# Rezoning Transportation Analysis

Petition Number: 2022-205

## Revision Log:

Date	Description
4-27-23	First Review (TM)
5-24-23	Second Review (DR)
6-13-23	Third Review (DR)

Rezoning Plan
Petition # 2022-205

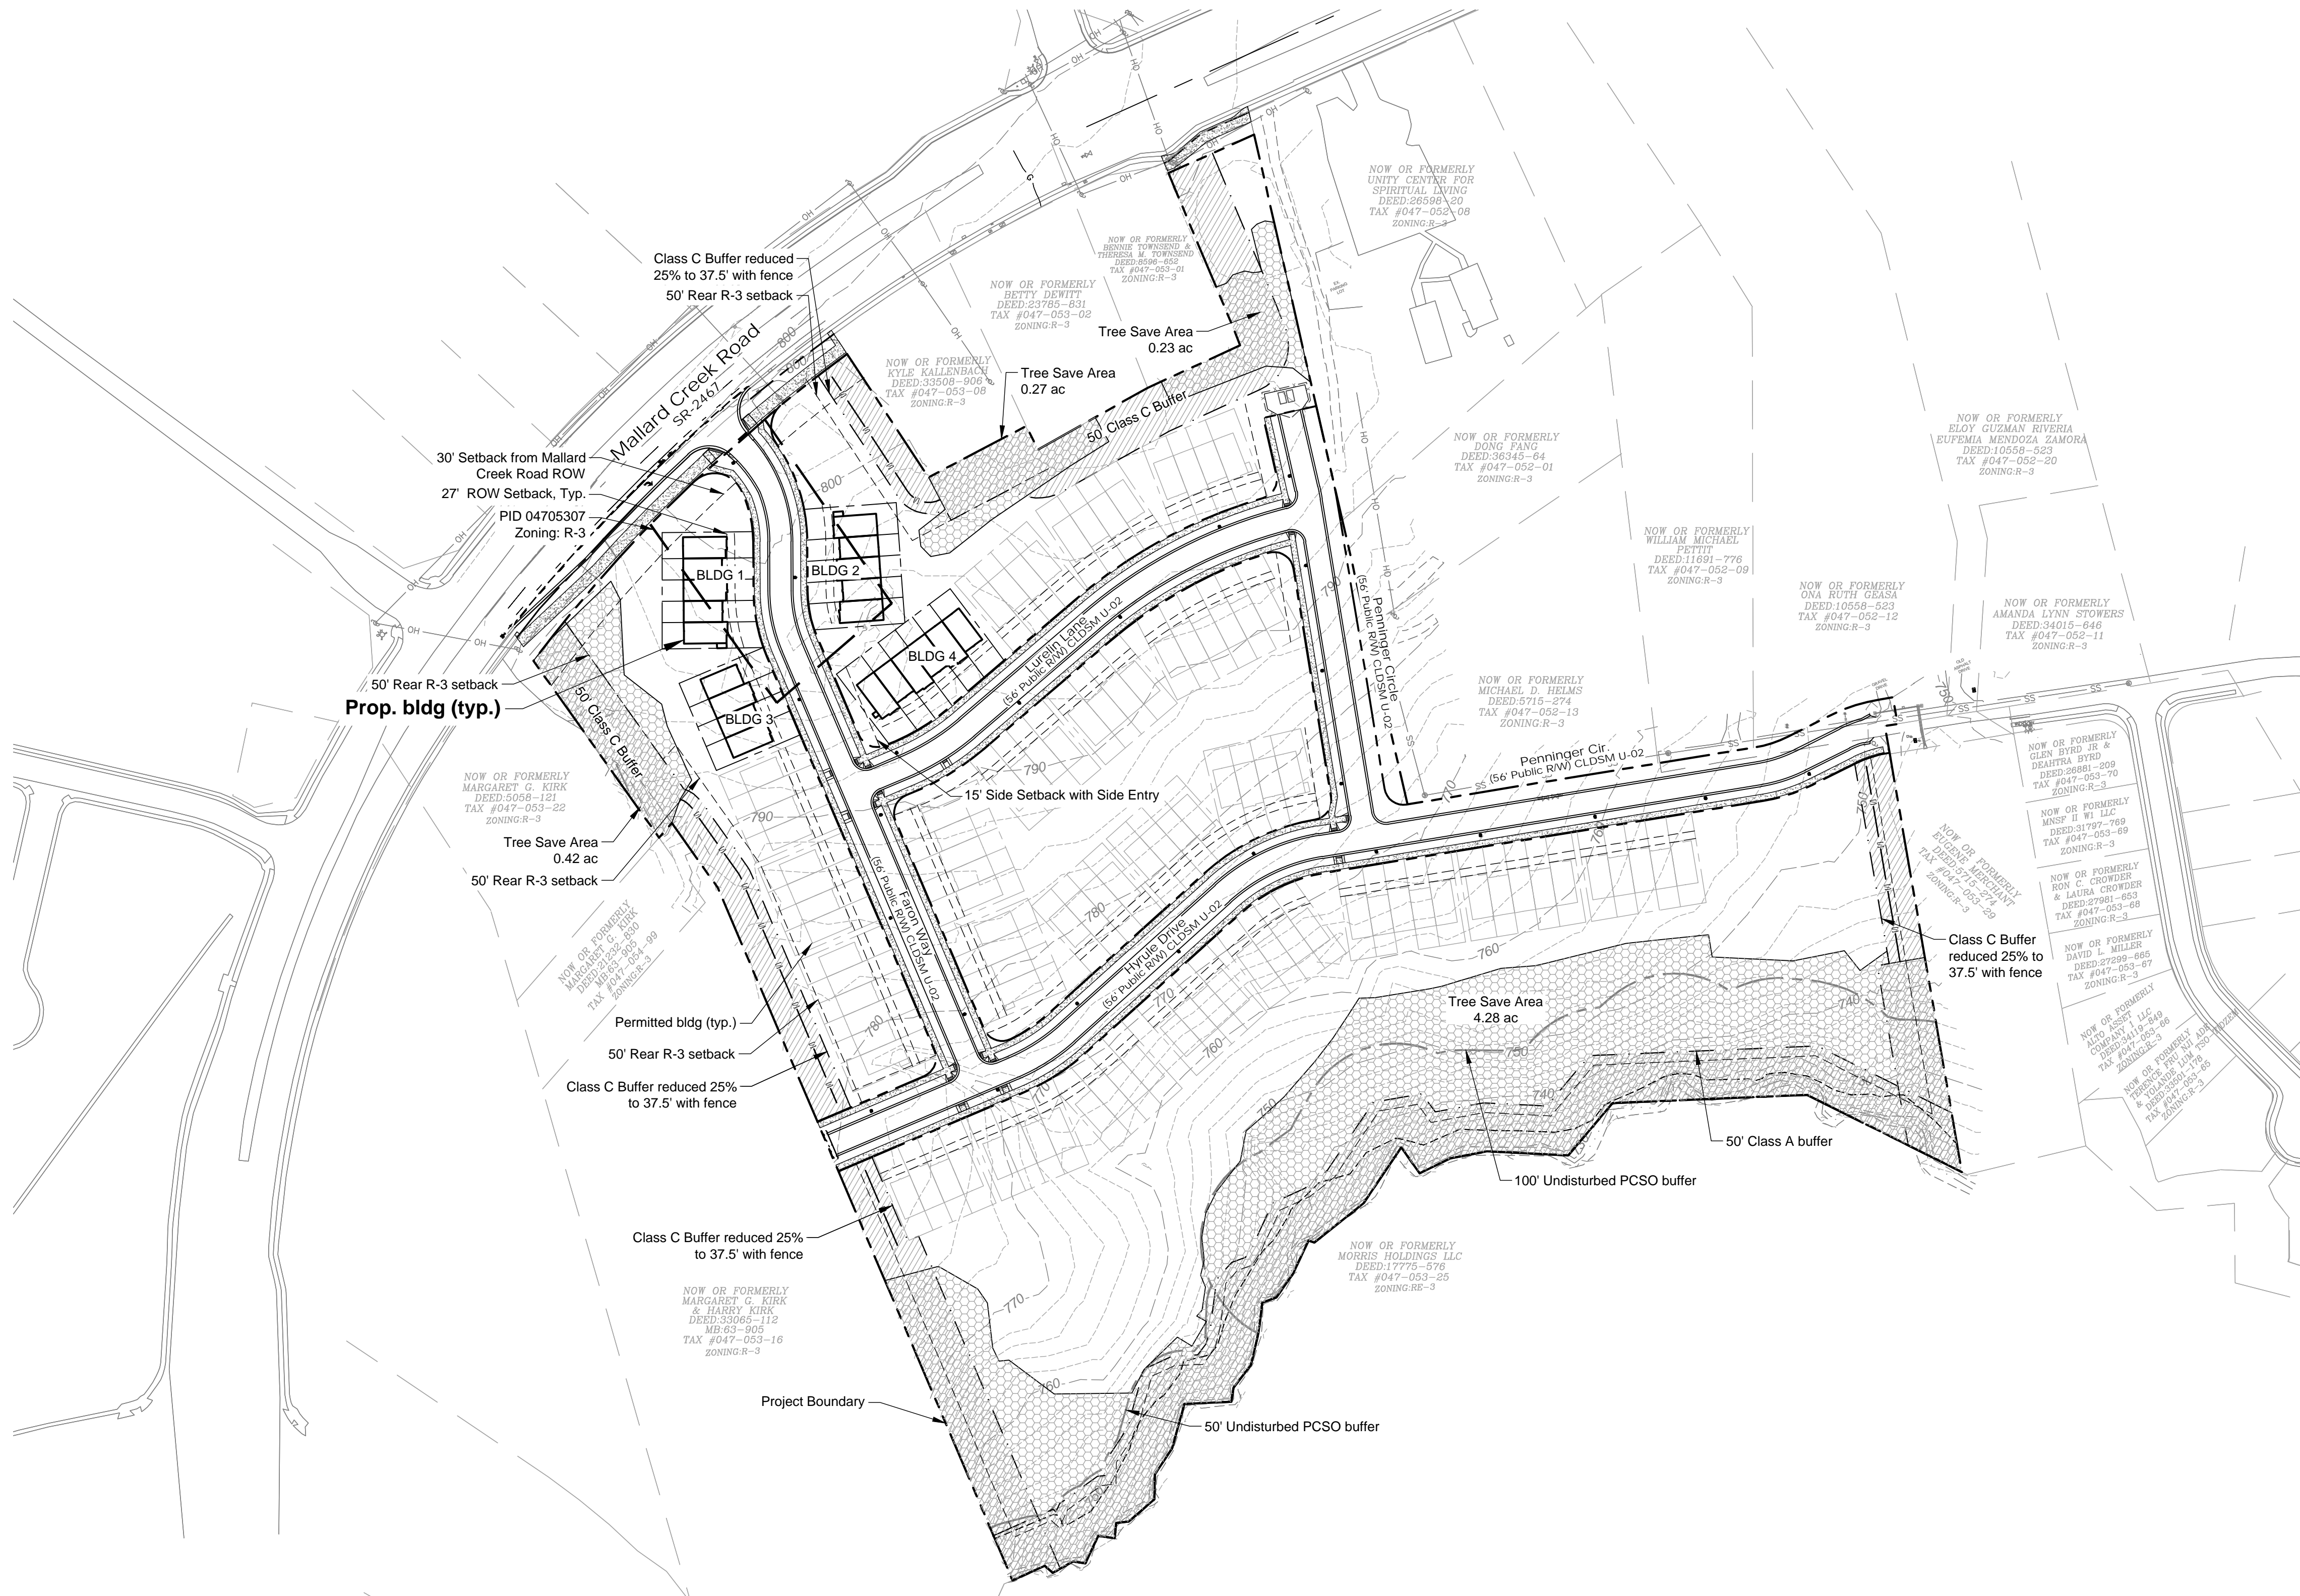
- Mallard Creek Road:** Location of curb and gutter to be moved to 33-feet feet from roadway centerline to accommodate the Charlotte Streets Map with a roadway typical section of 4+ Boulevard, Shared Use Path.

**Outstanding Comment from 04-27-23:** Label and dimension the curb and gutter from the centerline for each road on the site plan.

- Outstanding Comment from 04-27-23:** Revise site plan and conditional note(s) to commit to dedicate 50-feet of right-of-way from the road centerline. The site plan shall label and dimension the right-of-way from the road centerline.
- Outstanding Comment from 04-27-23:** Add a conditional note specifying "A Right-of-Way Encroachment Agreement is required for the installation of any non-standard item(s) (irrigation systems, decorative concrete pavement, brick pavers, etc.) within a proposed/existing City-maintained Street right-of-way by a private individual, group, business, or homeowner's/business association. An encroachment agreement must be approved by CDOT prior to construction/installation. Contact CDOT for additional information concerning cost, submittal, and liability insurance coverage requirements."
